Our ref.: SSD 5002-2011

**Royal Randwick Racecourse- Hotel (SSD 5002-2011)
Response to Submissions**

Attachment 1

NORTH ELEVATION

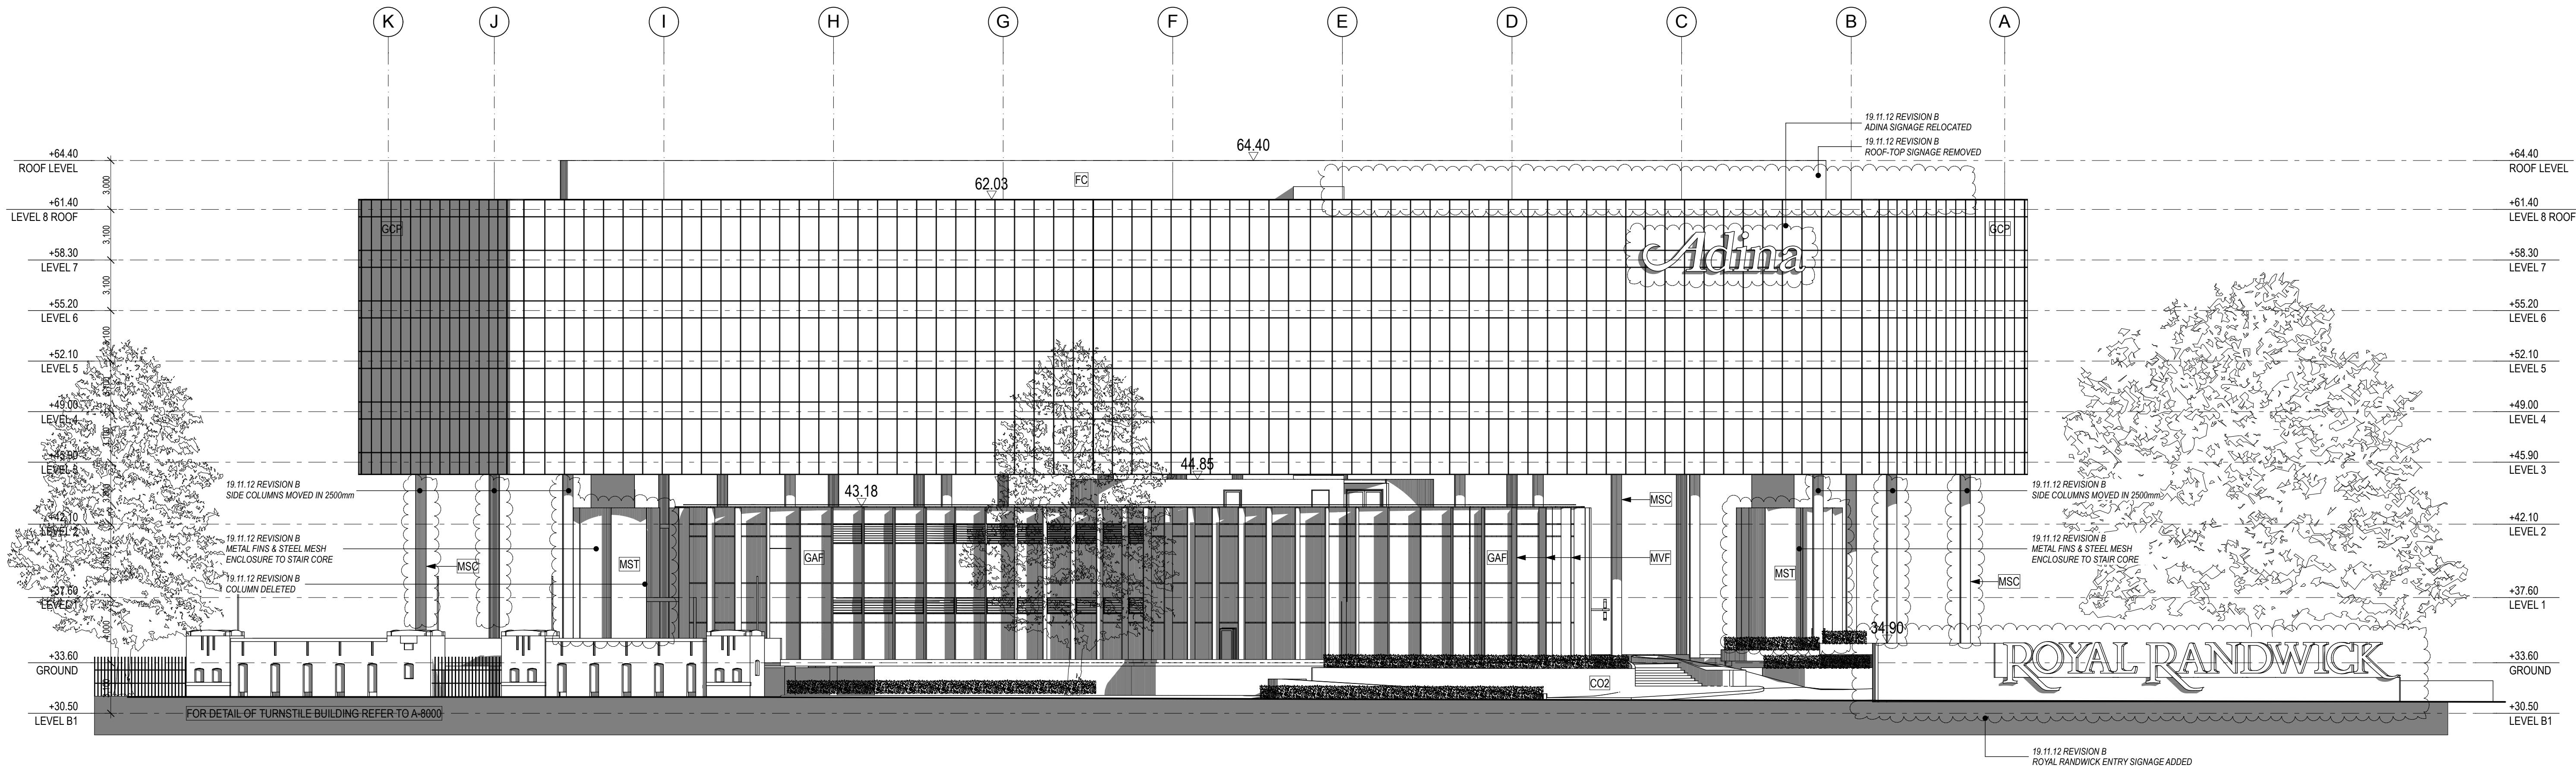
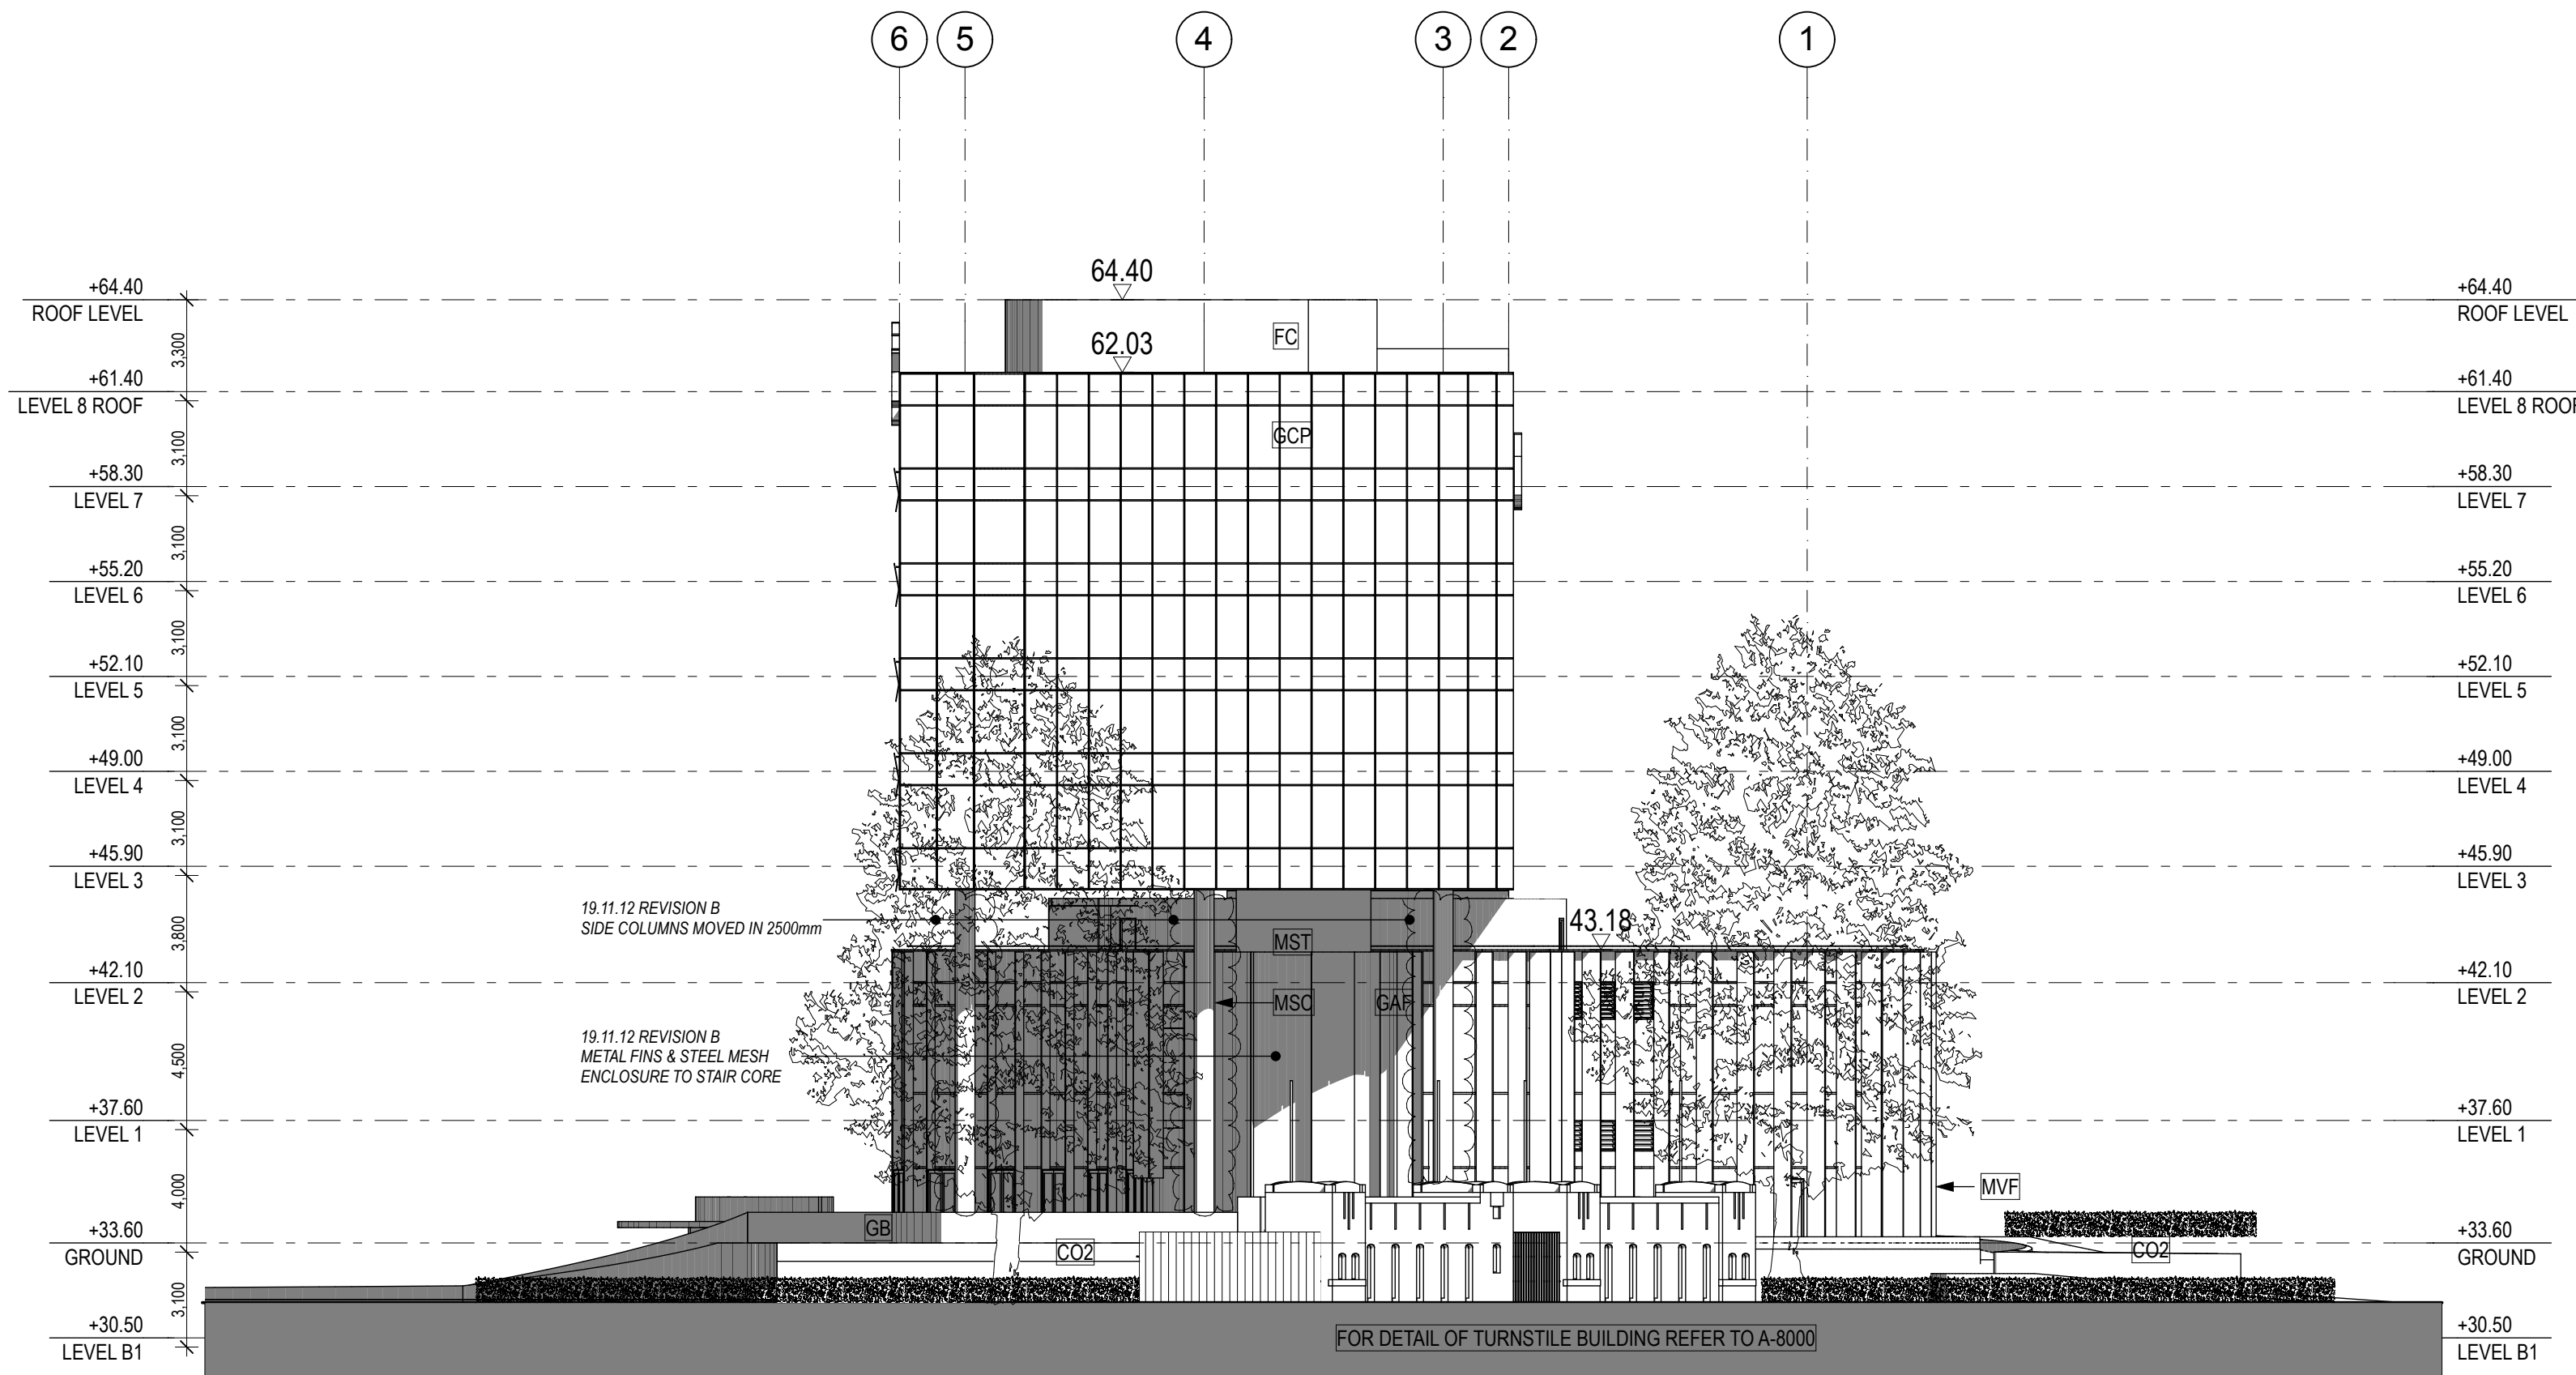
- the relationship of the proposed building with Alison Road, in terms of bulk and scale, with consideration given to opportunities to reduce visual impacts through the redistribution of building mass;

- the relationship of the building with Alison Road, including the location of back-of-house and building services, the provision of attractive frontages and building articulation; and

- the appropriateness of the proposed external façade treatment in terms of:
 - achieving a design appropriate for a 'landmark building';
 - the exposed support columns, fire escape stairs and exposed underside of the upper levels;

DRAWING NO A-9001	REVISION B

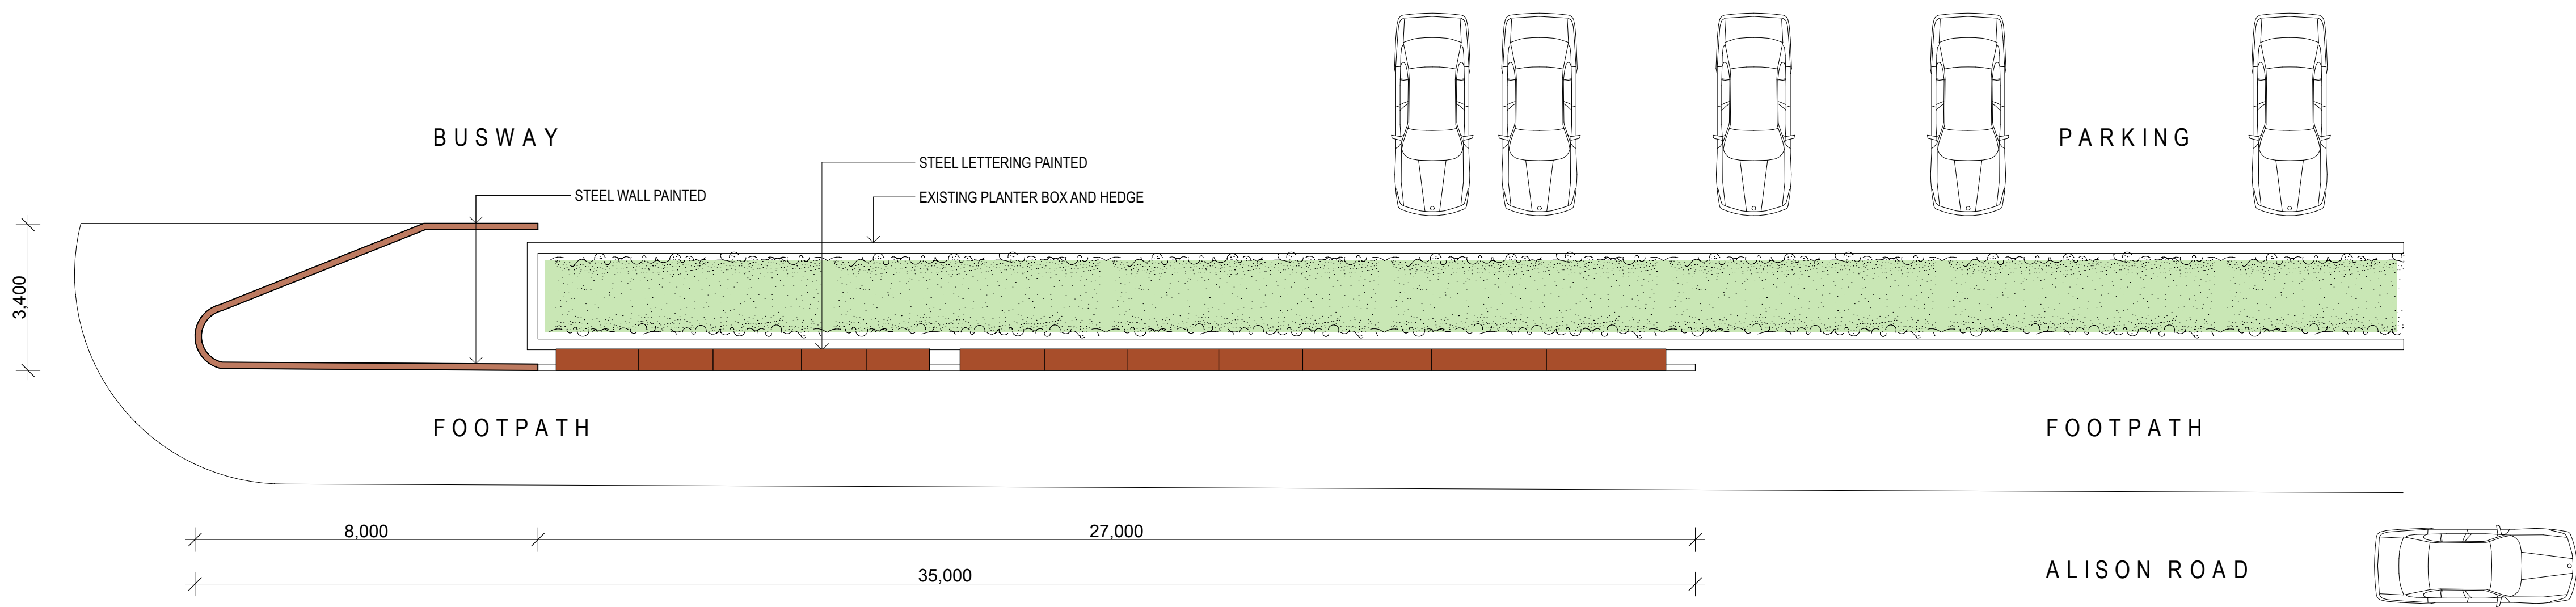
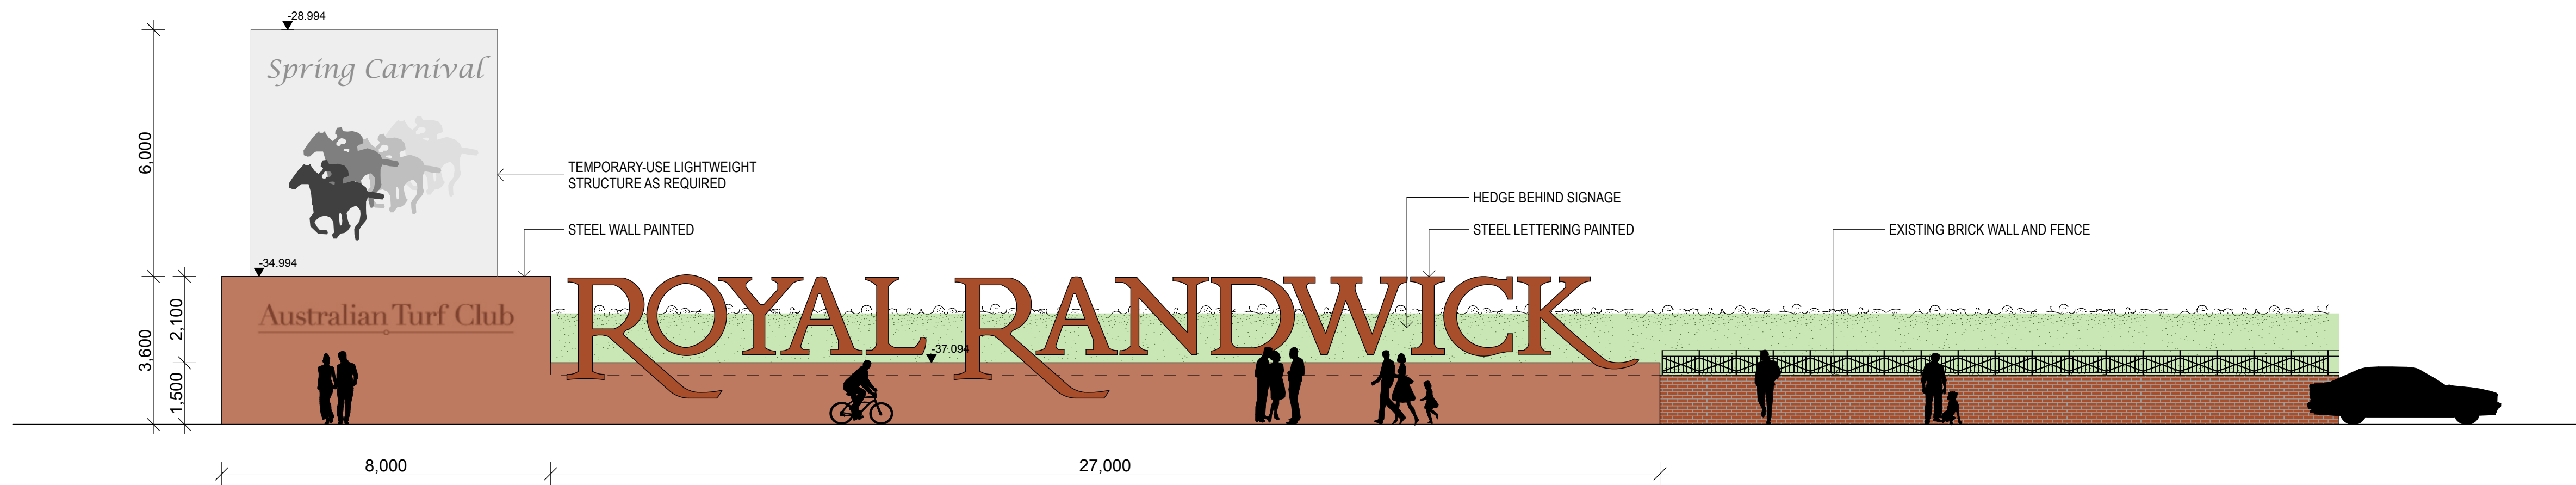
- The proposed roof signs are not considered consistent with the objectives for open space zones, identified within the Randwick Outdoor Advertising DCP. Consideration should be given to the incorporation of the signage into the building façade (not extending above the building parapet) and the use of a sympathetic size, design, colours and illumination, compatible with the site's status as a Conservation Area.
- An assessment of the proposed signage against relevant sections of the NSW Heritage Office's (now Branch) publication 'Statements of Heritage Impact' should be provided, (available at: <http://www.environment.nsw.gov.au/resources/heritagebranch/heritage/hmstatementsofhi.pdf>).

- additional detail of proposed ground floor level signs including their height above ground level, whether fixed or free standing and relationship with other signage;
- further information regarding the historical significance of the following structures/features:
 - further detail including a description and history of the second Stewards' Tower, proposed for removal;
 - the existing path and associated planting adjacent to Alison Road;
- details of the proposed interpretation panels to the Turnstile building, including how they relate to the Godden Mackay Logan Conservation Management Plan, what information is to be displayed.
- a Landscape Impact Statement prepared by a suitably qualified professional, assessing the historic significance of the site's previous and existing landscaping schemes including.
